Sheringham and Dudgeon (Windfarm) Extension Projects

Perenco UK Limited Summary of Written Representation

Perenco UK Limited (PUK) has prepared a Written Representation (titled: *Sheringham and Dudgeon (Windfarm) Extension Projects, Perenco UK Limited Response to Examiner Deadline 1*) for Deadline 1 of the Examination of the Development Consent Order (DCO) application for the Sheringham and Dudgeon Extension Projects.

Figure 7.1 Route Deviations to Key O&G Assets

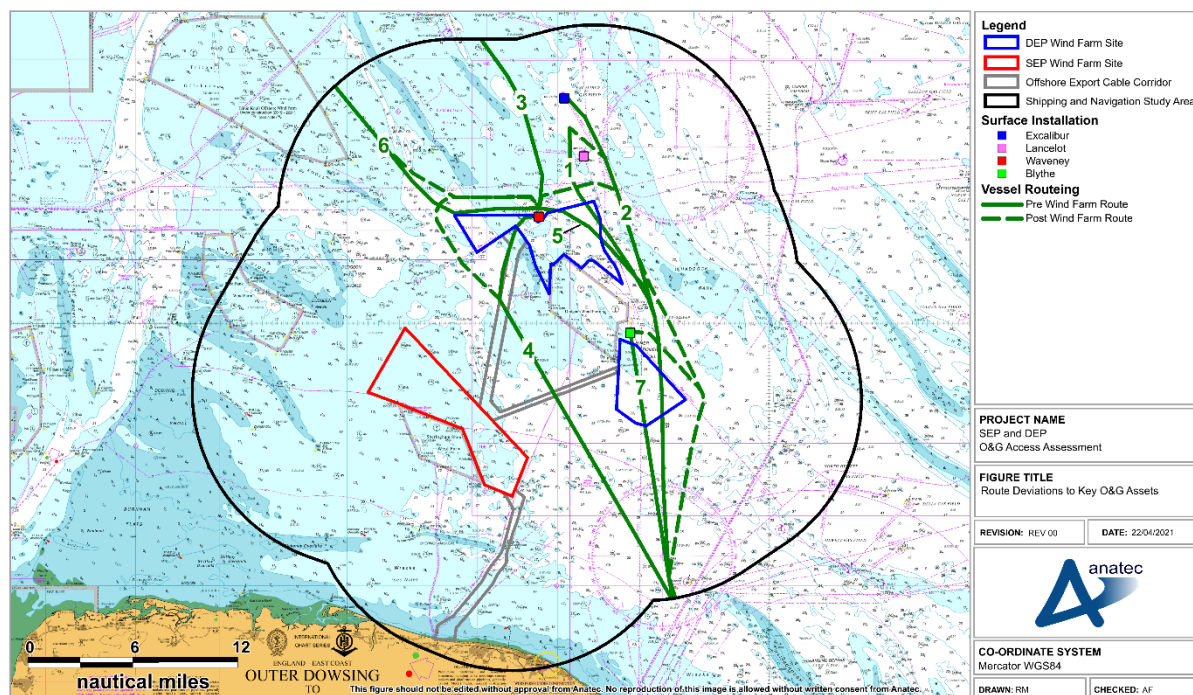
15. A 1km wide corridor (500m either side of the pipeline) free from surface obstructions would also be required along the line of the Durango to Waveney pipeline to permit vessel access.

Figure 6.1: SEP and DEP Asset Overview

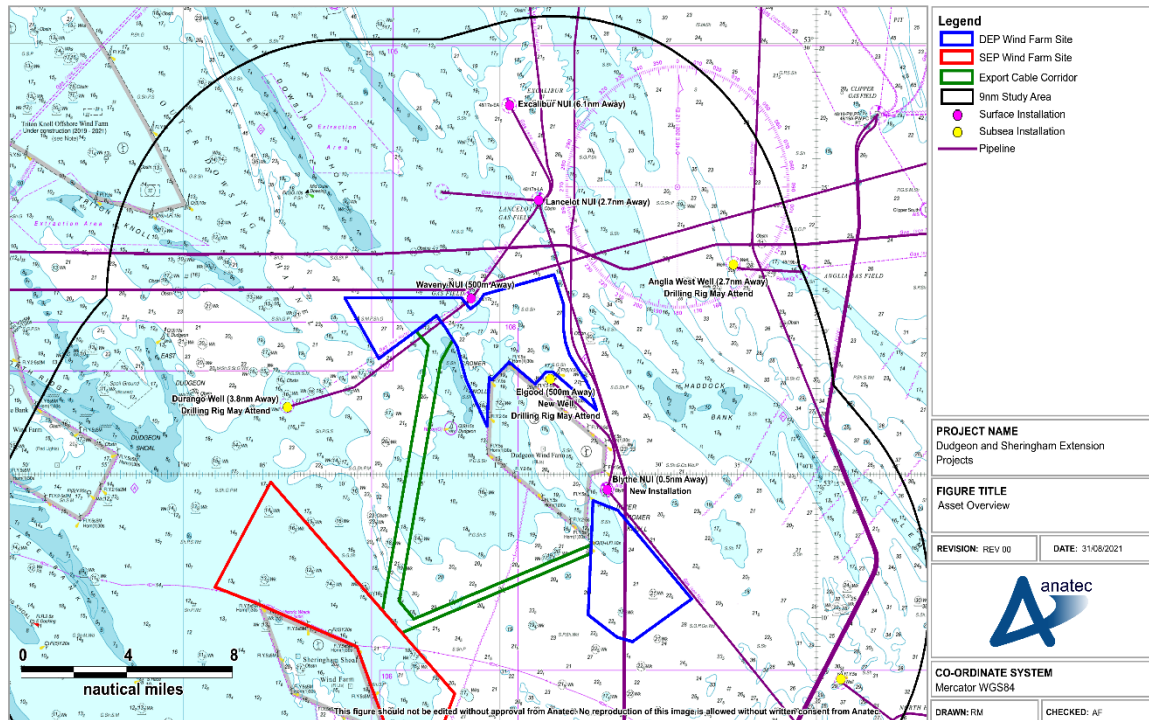
8. PUK has assessed the impact of the proposed windfarm on helicopter and marine operations and also on telecommunications.
9. PUK believes that the Applicant, based on the *Helicopter Access Study* (APP-205) conducted by Anatec Ltd (Anatec), has significantly understated the impact of the proposed DEP North on helicopter operations in support of Waveney and Durango operations.

10. The main difference in view arises from Anatec assuming that flights can be made whenever CAA minimum conditions are satisfied. In fact, North Sea Helicopter Operators impose more onerous conditions for flying in proximity to wind turbines. These conditions are expected to soon be incorporated into CAA policy and guidance.

11. The Applicant's proposal to place wind turbine generators 1nm from the Waveney NUI would preclude production of gas from the Waveney field and prevent the Waveney NUI from being decommissioned and dismantled. PUK would thus be prevented from fulfilling its statutory obligations under the production licences already awarded to it.

12. PUK assesses that an obstacle-free radius of 1.5nm around the Waveney NUI would permit some helicopter operations but that this would result in severe restrictions relative to the current situation and thus have a very significant detrimental impact on PUK's Waveney and Durango operations.

13. PUK believes that a 3nm radius obstacle free airspace around the Waveney NUI would be necessary for successful co-existence. This is based on the distance to a wind
